Appendix A

This document is appendix A to the covering letter from the applicant dated 22 December 2023. It provides responses to the comments issued by the Planning Inspectorate on 17 November 2023 under Section 51 of the Planning Act 2008 and the comments provided within the checklist completed under section 55 of the Planning Act 2008.

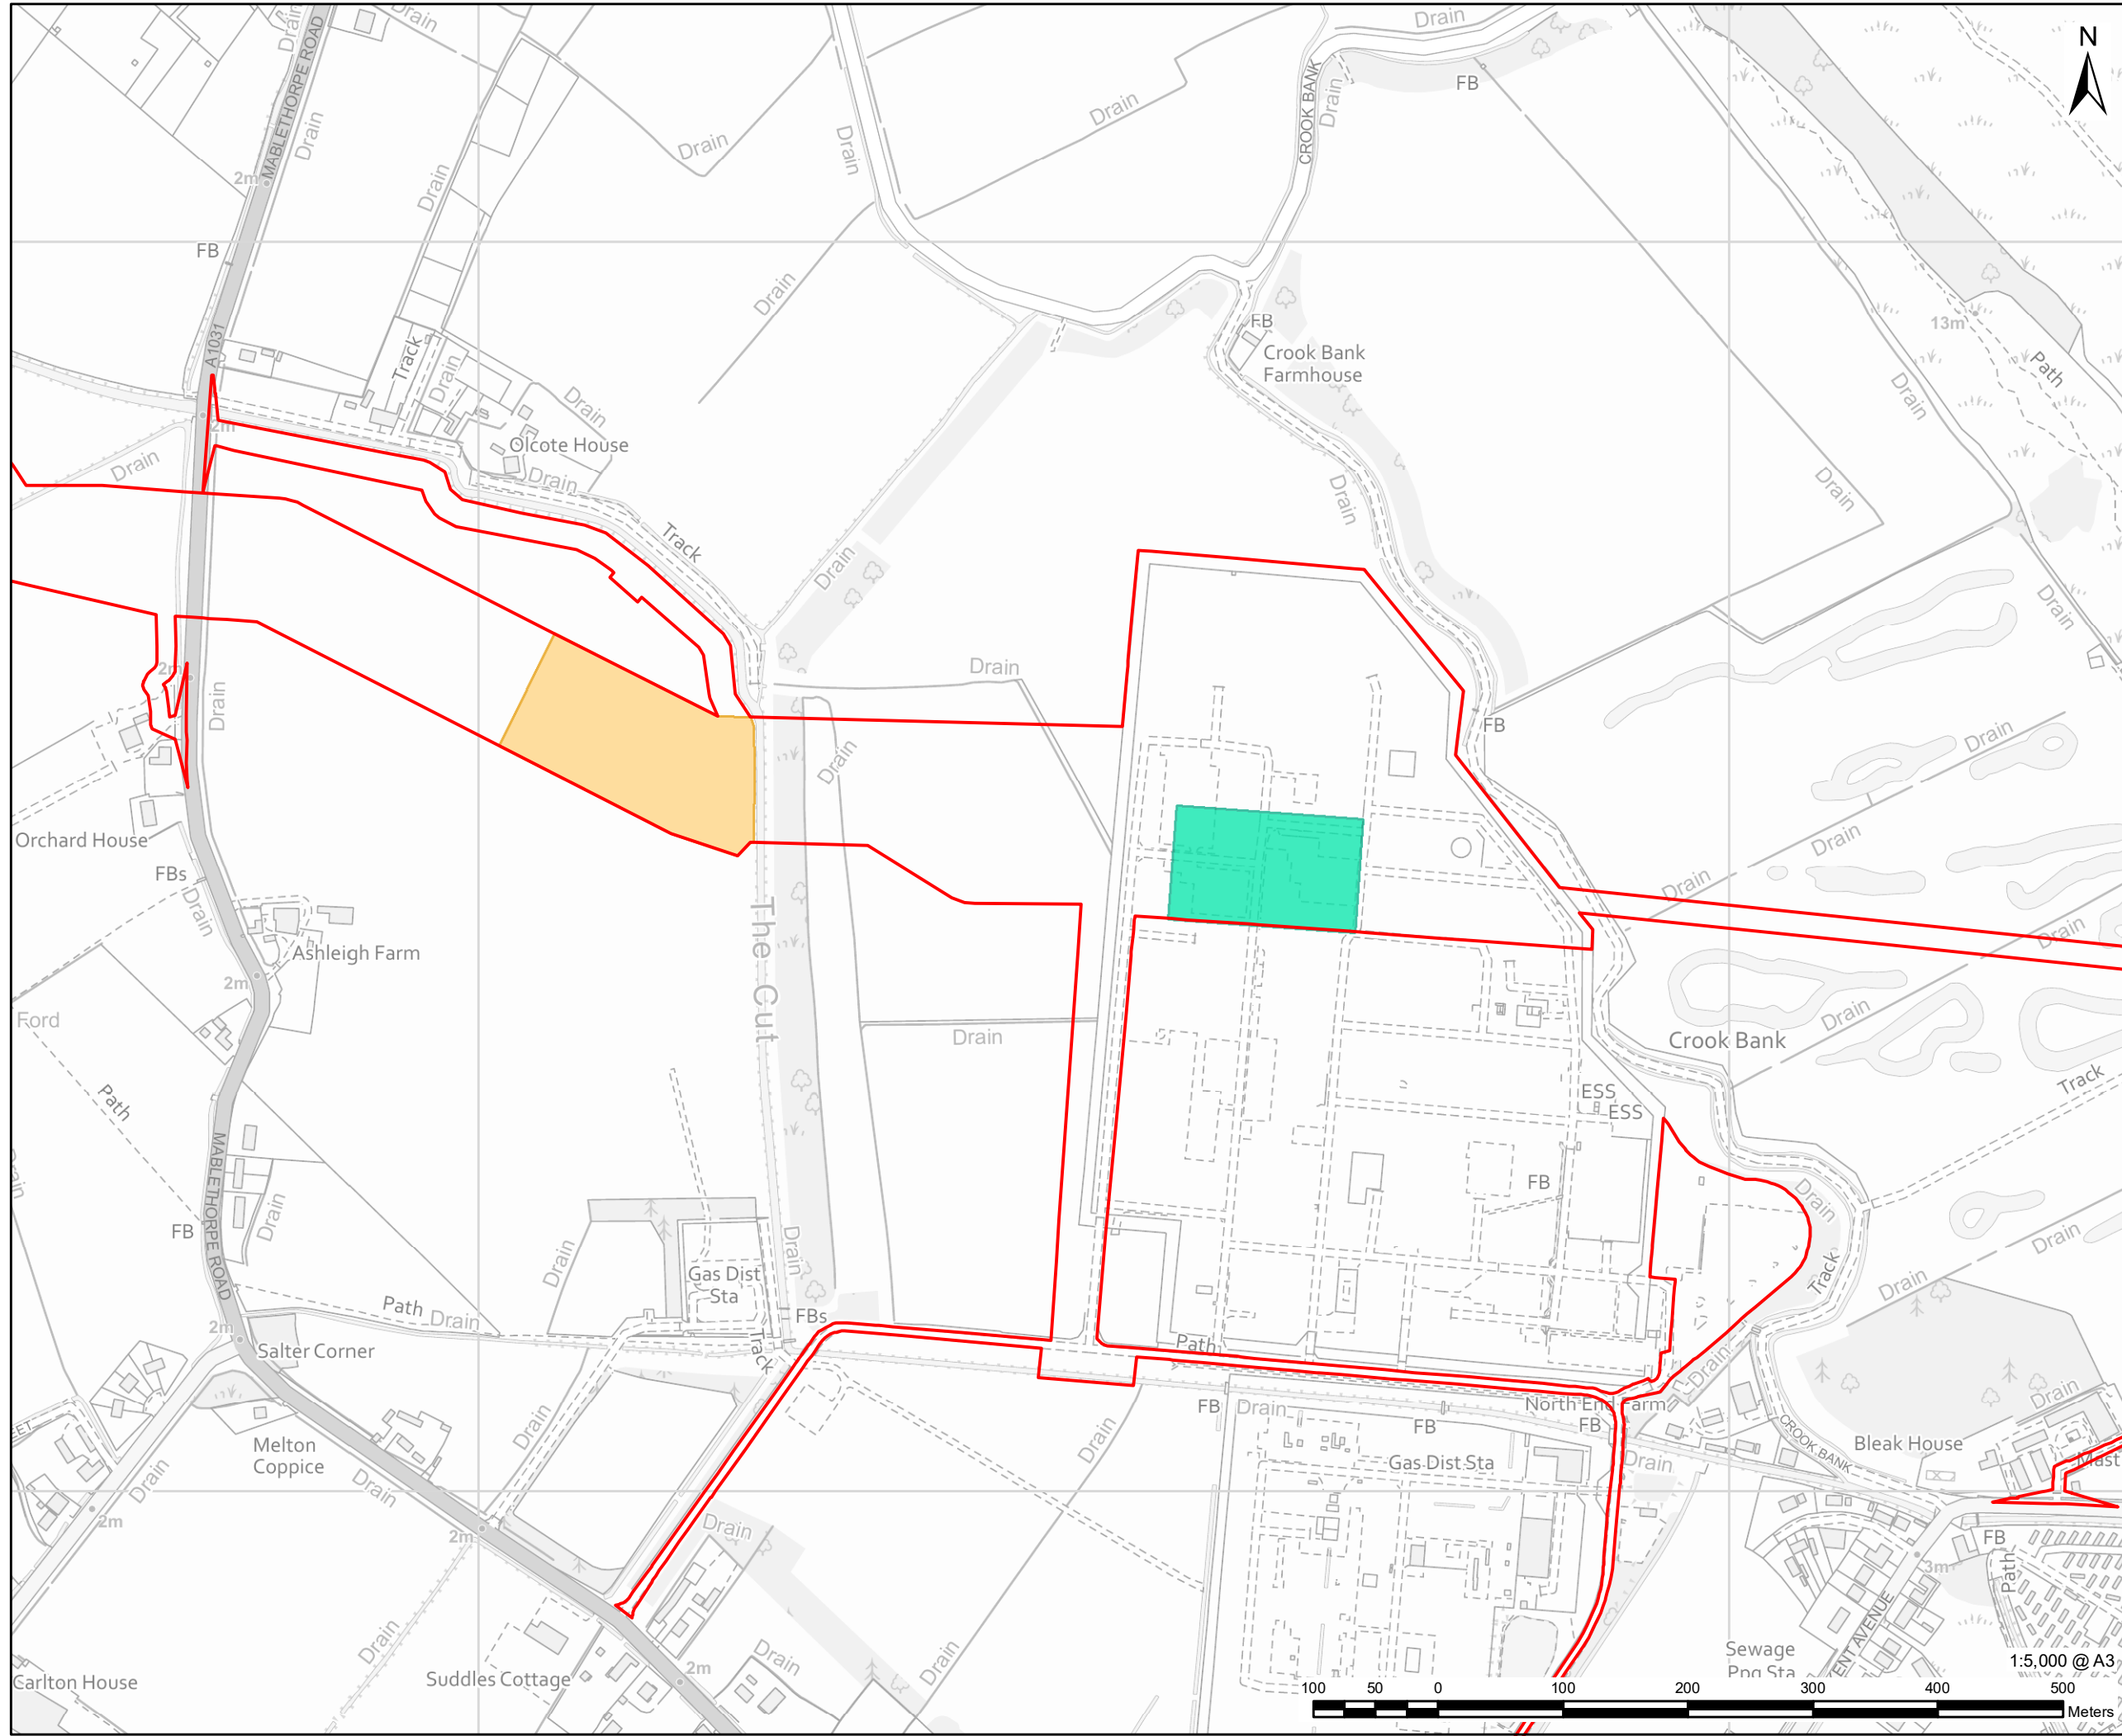
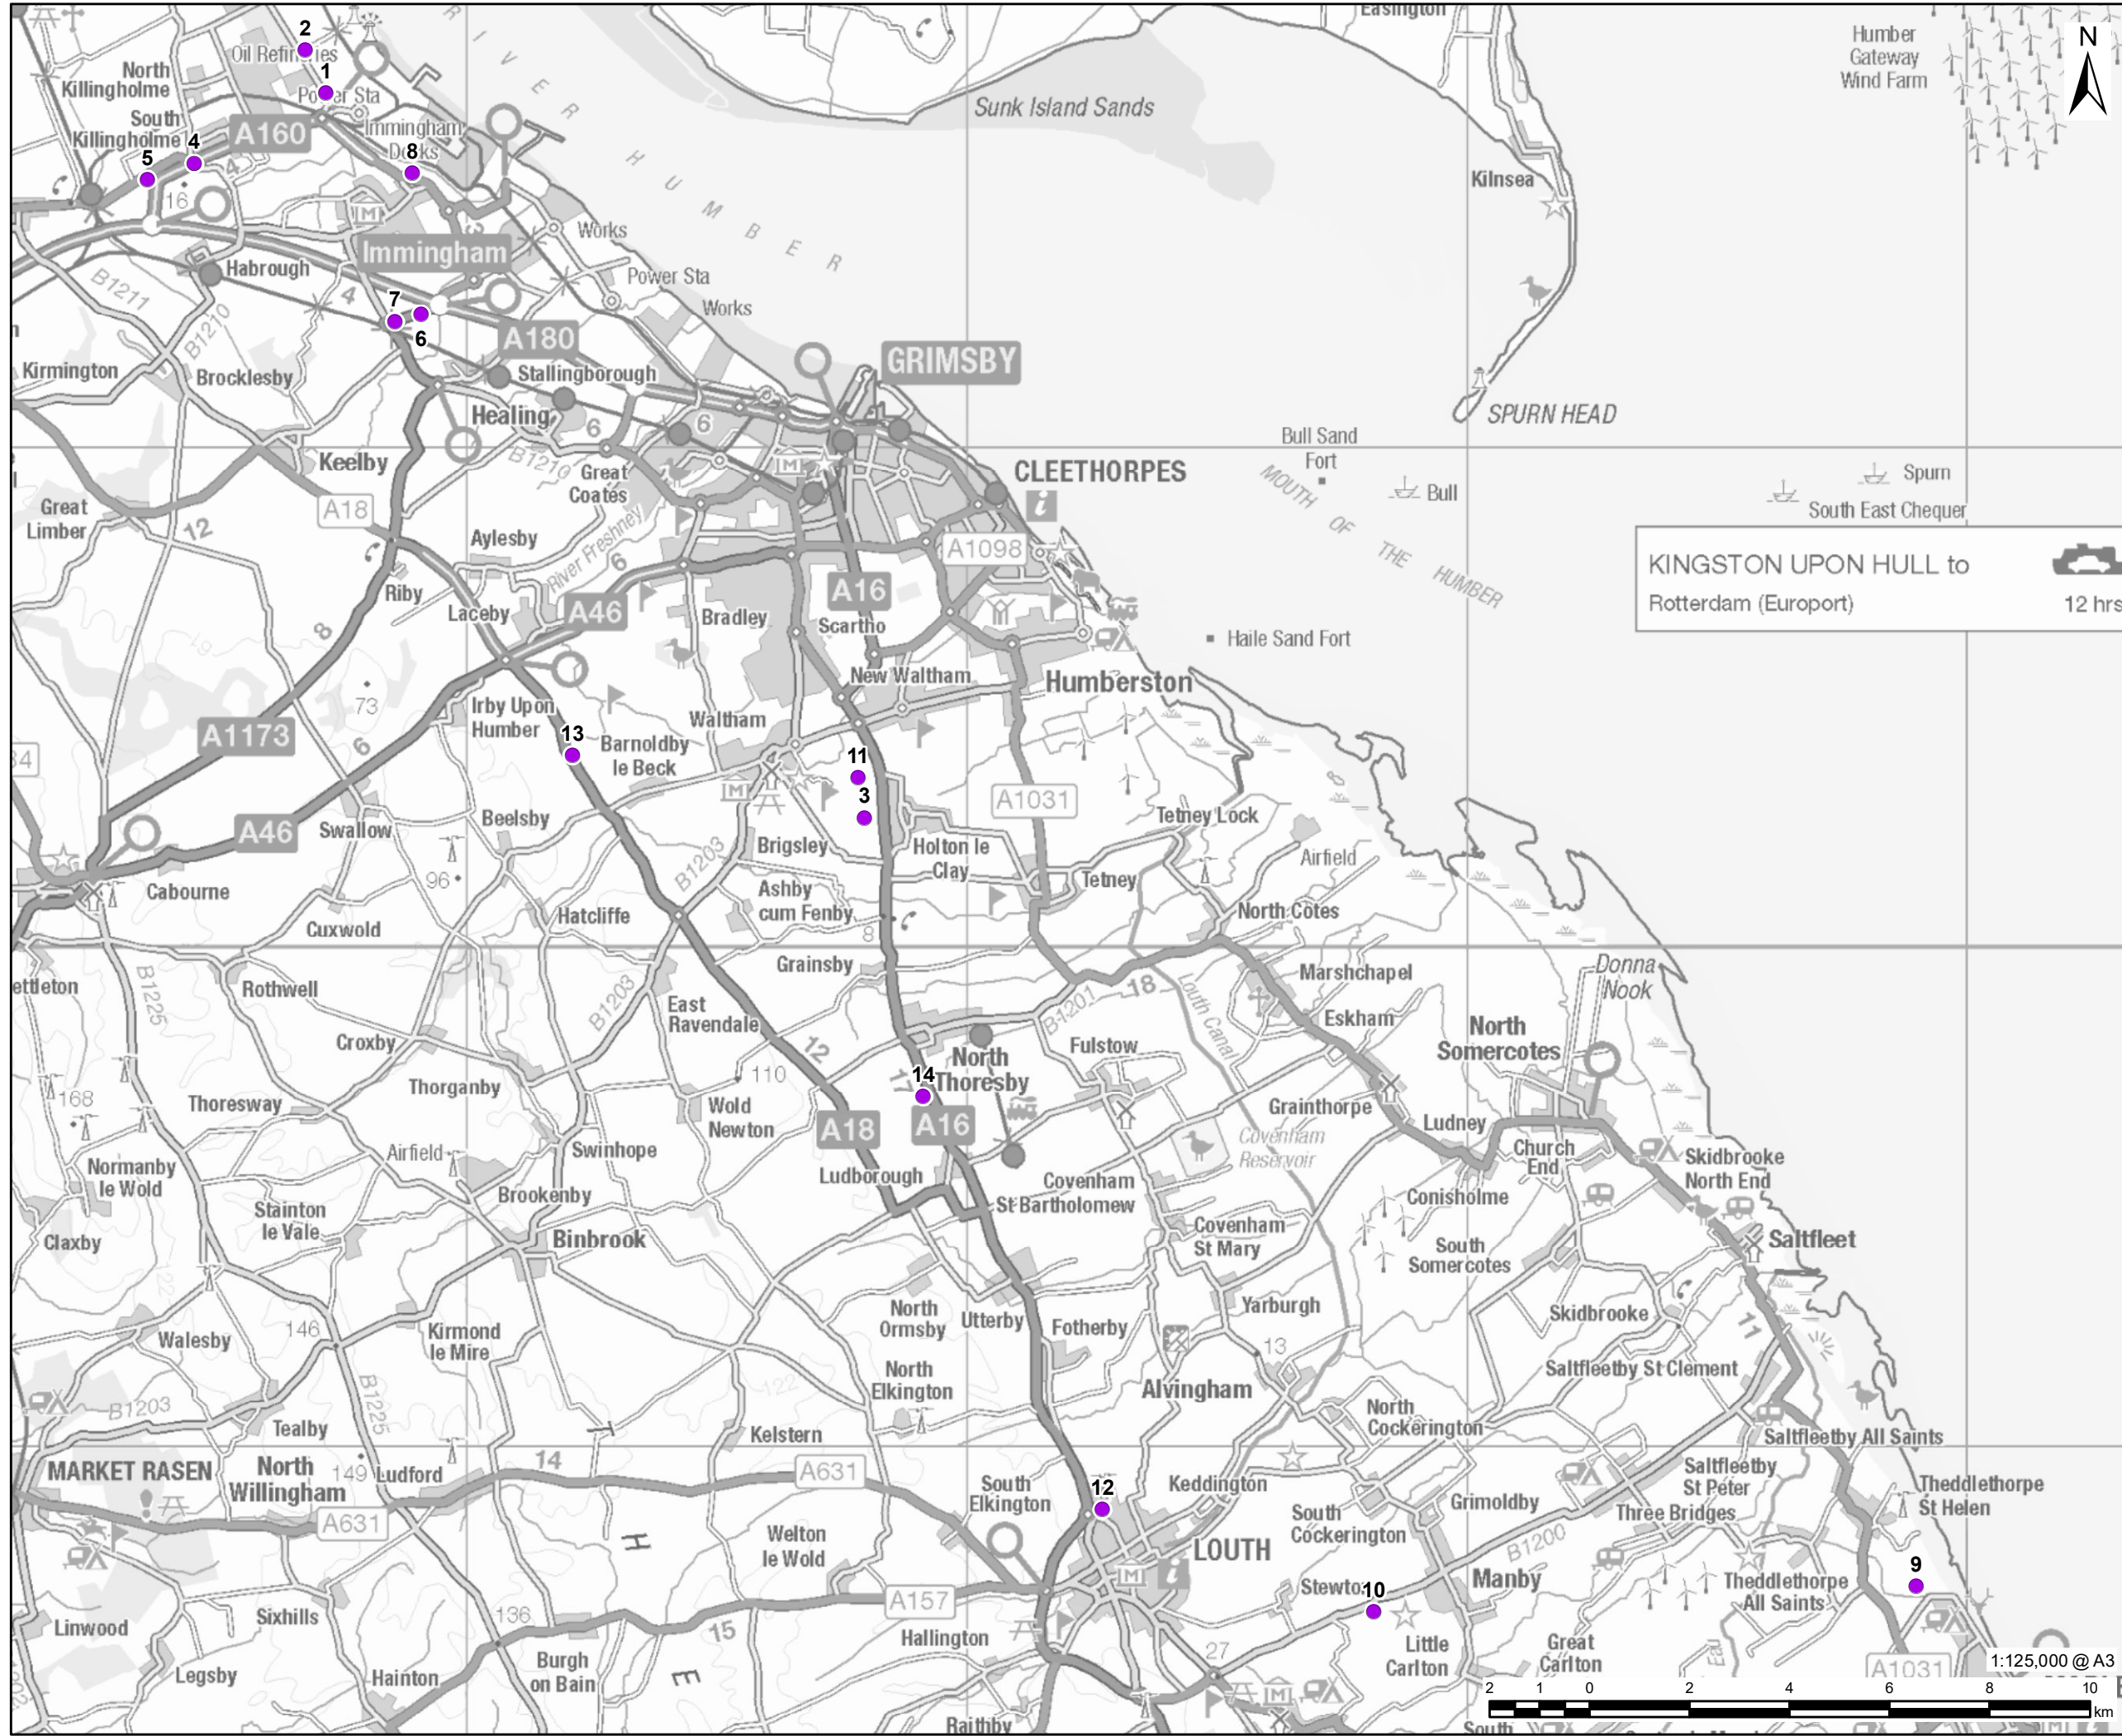
Planning Inspectorate Comments	Applicant Response
	<p>Authorities. As such, the Applicant does not consider it necessary to add any further detail to this table.</p>
<p>Environmental Statement (ES)</p> <p>ES Chapter 2 Figures 2-7 and 2-8 do not appear to wholly correspond with the supporting text in paragraphs 2.9.14 or 2.9.20 above.</p> <p>In plans showing Statutory / Non-Statutory Features of the Historic Environment (Doc 6.10), the figures are labelled in full. In ES Volume III – Figures: Part 2 of 3 (Doc 6.3.2) they are labelled with the gazetteer number (unique identifier) only. ES Volume II – Chapter 8: Historic Environment (Doc 6.2.8) does not refer to the location of this gazetteer table so reading the ES figure alone may lead to confusion as to what is being represented by the numbers on the figure.</p> <p>Information is provided in full in plans showing Statutory and non-statutory nature conservation sites (Doc 6.9.1), however not all sites from this are labelled on the equivalent figures in Doc 6.3.2 (ES Figures) and ES Chapter 6: Ecology and</p>	<p>The references have been updated accordingly in chapter 2. Where previously the text states Figure 2-7, this has now been changed to Figure 2-8 and where it stated Figure 2-8, this has been updated to refer to Figure 3-30. Consequently, ES Volume II Chapter 2 has been updated (6.2.2 – Revision A). These were the only changes made to the document and an updated version is provided.</p> <p>The Applicant has added an additional statement within ES Volume II – Chapter 8 Historic Environment which clarifies the labelling used on figures within the ES and within the Application Document 6.10. In particular, the new statement makes reference to the gazetteer table (Annex A of ES Volume III Appendix 8-1) to help the reader understand what information is displayed on the figures within ES Volume III. The Applicant has also made reference to the separate plans provided within Document 6.10 and noted they are fully labelled to help the reader understand the presentational differences on the figures presented. This new information is provided on page 8-51, of the updated version of ES Volume II: Chapter 8 Historic Environment (6.2.8 – Revision A). This is the only change made and an updated version is provided.</p> <p>The Plans of Statutory / Non-Statutory Sites or Features of Nature Conservation [APP-119] includes details of all sites with designations relating to (i) nature conservation, (ii) geology and</p>

Planning Inspectorate Comments	Applicant Response
<p>Biodiversity (Doc 6.2.6) (boundaries etc are represented but no labels).</p>	<p>(iii) landscape importance. Not all of those are relevant to consideration of the potential effects of the development on ecology, which is assessed in ES Chapter 6: Ecology and Biodiversity [APP-048]. Only the designated sites relevant to ecology are shown on figures within that that chapter and the associated figures [APP-065].</p>
<p>Flood Risk Assessment ES Volume IV – Appendix 11-3 (Doc 6.4.11.3) makes reference to annexes A to D, but these annexes have not been provided.</p> <p>No figures have been provided to demonstrate the proposed location and extent of sustainable drainage systems (SuDS) measures for each site described in the Drainage Strategy.</p>	<p>An updated version of the Drainage Strategy has been submitted including the missing Annexes (no other changes were made to the main report) and an updated version is provided (6.4.11.3 – Revision A)</p> <p>A copy of the proposed drainage plans is now included within Annex C of the updated Drainage Strategy.</p>
